HOMESTEAD AT STERLING RANCH FILING NO. 2

AMENDED STORM SEWER PLANS: REAR LOT SAND FILTER RELOCATIONS

REPLACES AND AMENDS SHEETS ST11 AND ST12 OF THE
"HOMESTEAD AT STERLING RANCH FIL. NO. 2 STORM SEWER PLANS (SF-19-04)" DATED 3/5/2020, BY M&S CONSULTANTS

**NORTH SAND FILTER
EMERGENCY SPILLWAY**
SCALE: 1"=2'

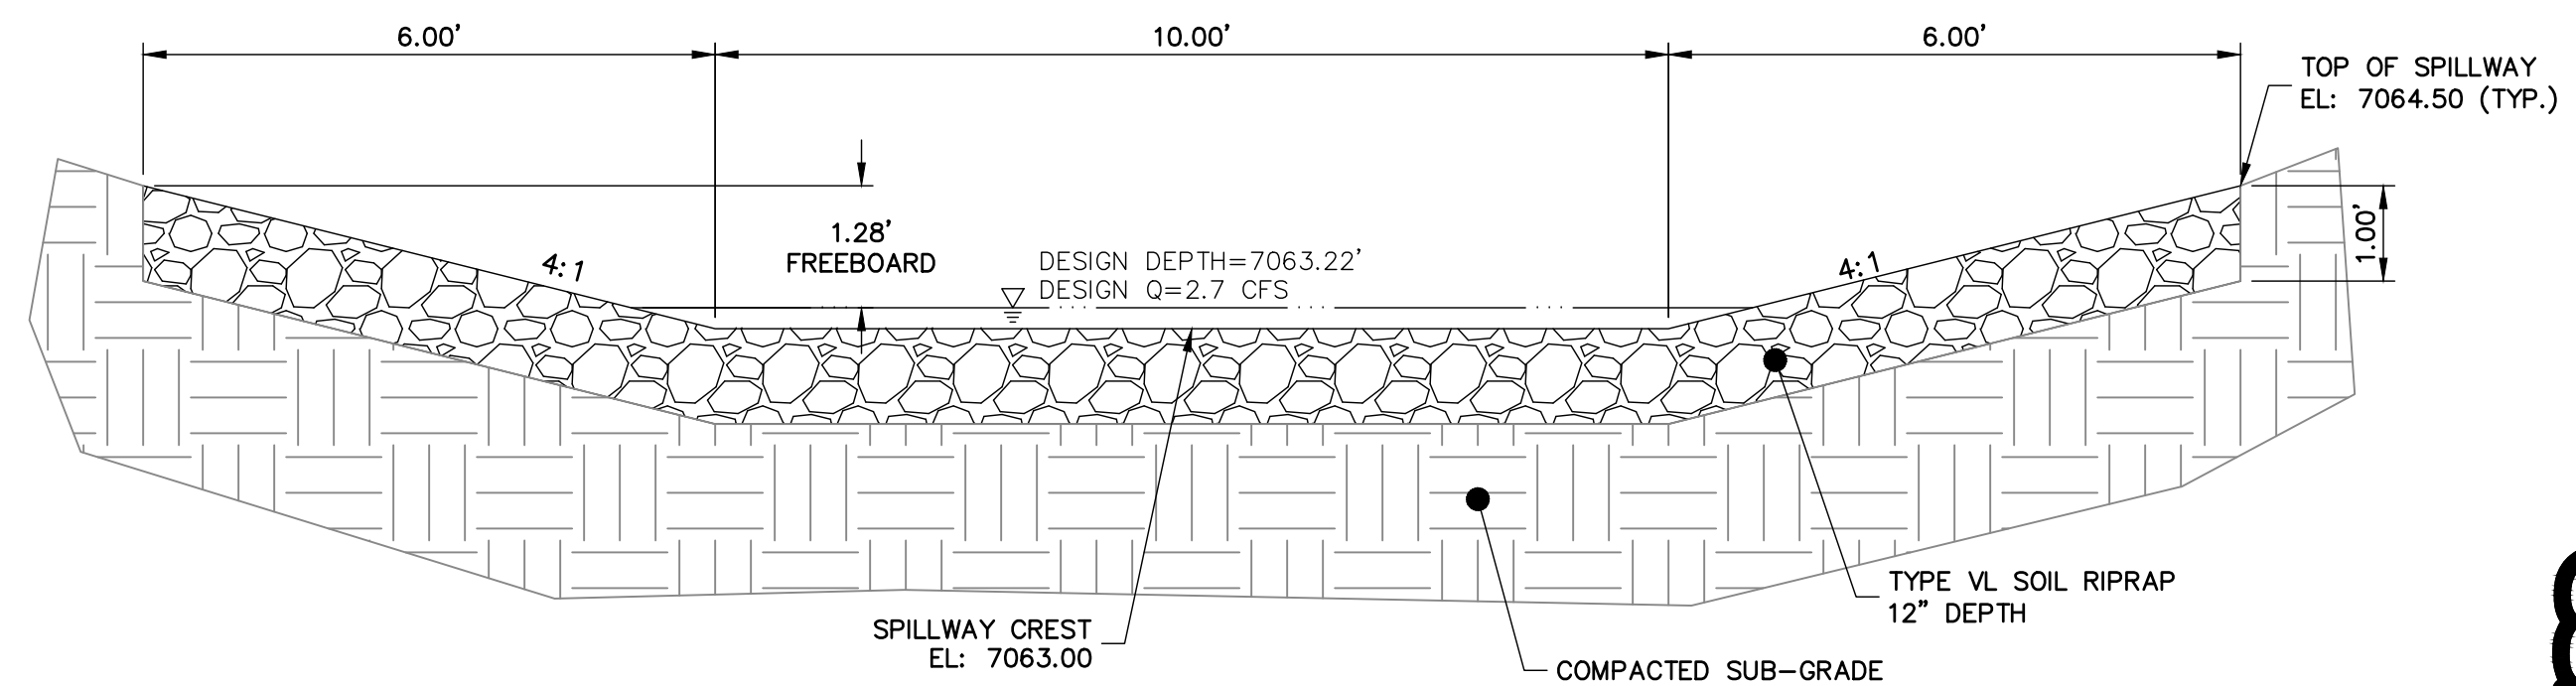
Show spillway details for both SFBs
